Proposed single storey earth sheltered extension to form new kitchen annex, (Listed Building Consent)
At Mill Farm, New Road, Gunthwaite, Sheffield, S36 7GE

2024/0158

Condition(s) - Variation/Removal

title **Ground Floor Plan and Site Layout as Proposed**
 number **22046D-21-P06**
 scale **1 : 50**
 size **A1**

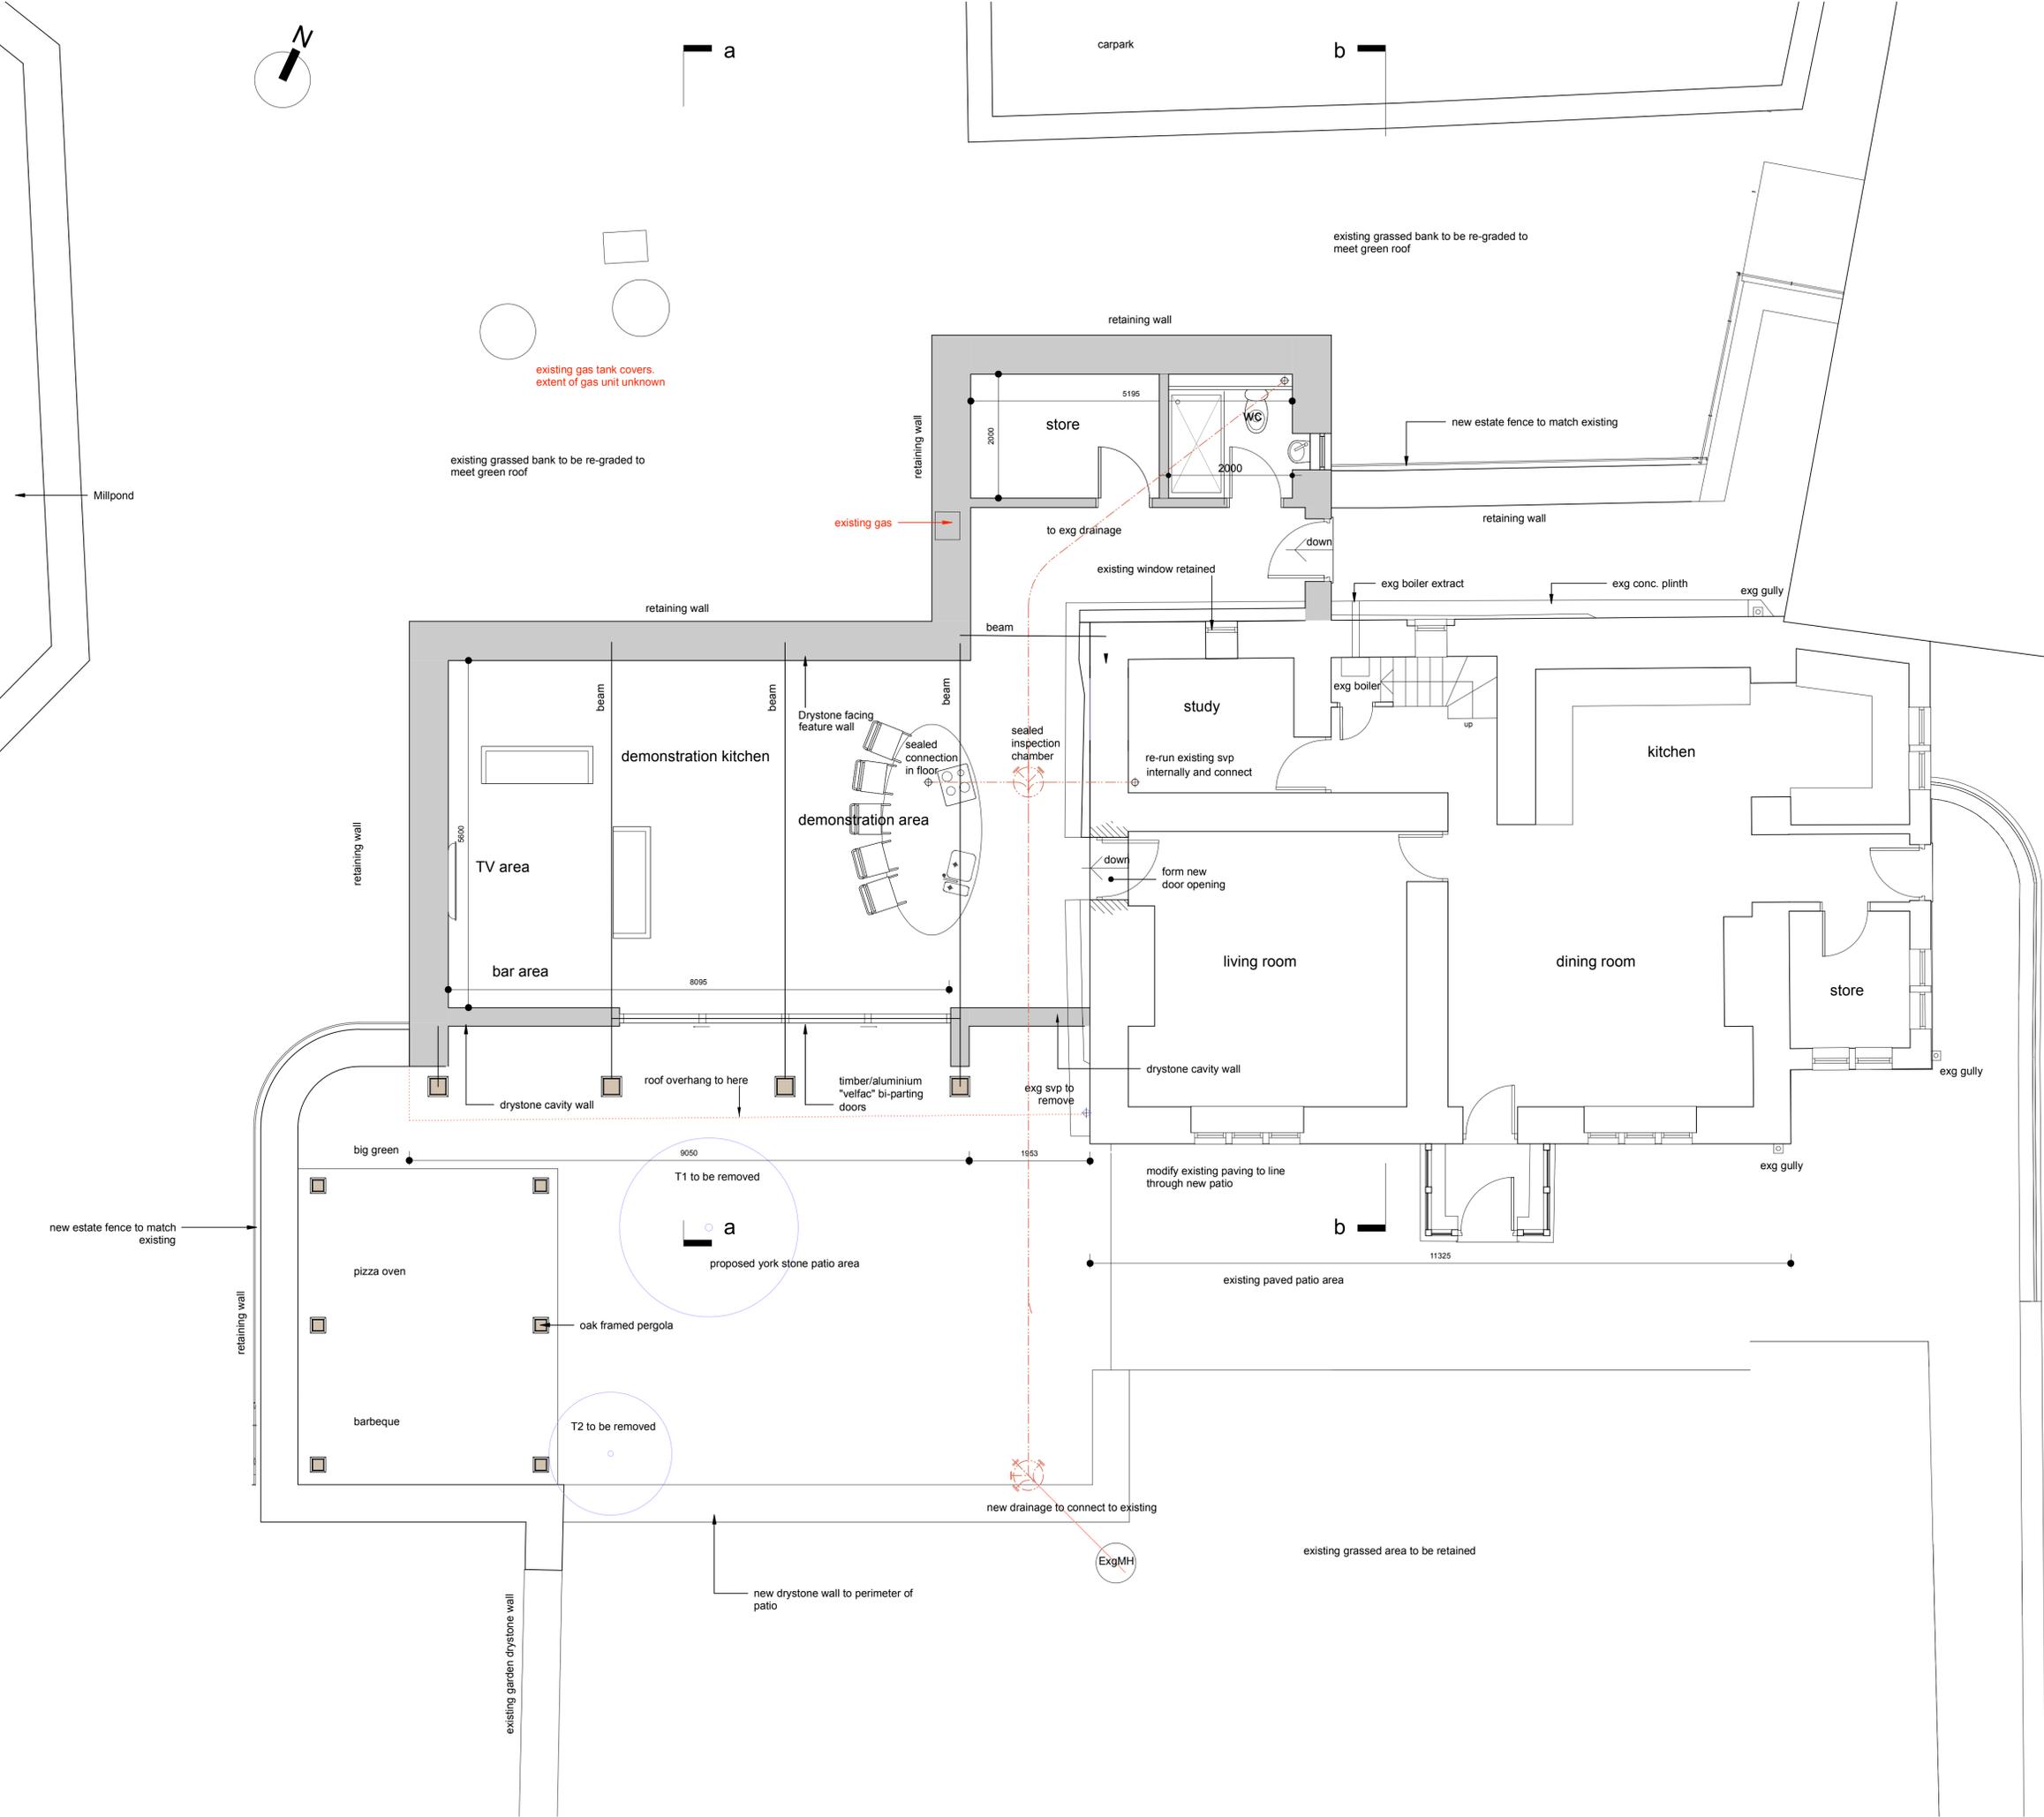
The layout of the proposed Ground Floor Plan has been changed

The Decision Notice at Condition 2 states that "The development hereby approved shall be carried out strictly in accordance with the plans and specifications as approved" The decision notice refers to drawing nr 22046 - 21 - P05, Ground Floor Plan and Site Layout as Proposed (1:50) which has been superceeded.

The decision notice should therefore be varied to refer instead to drawing nr 22046 - 21 - P06, Ground Floor Plan and Site Layout as Proposed (1:50), which shows the new layout for which permission is required.
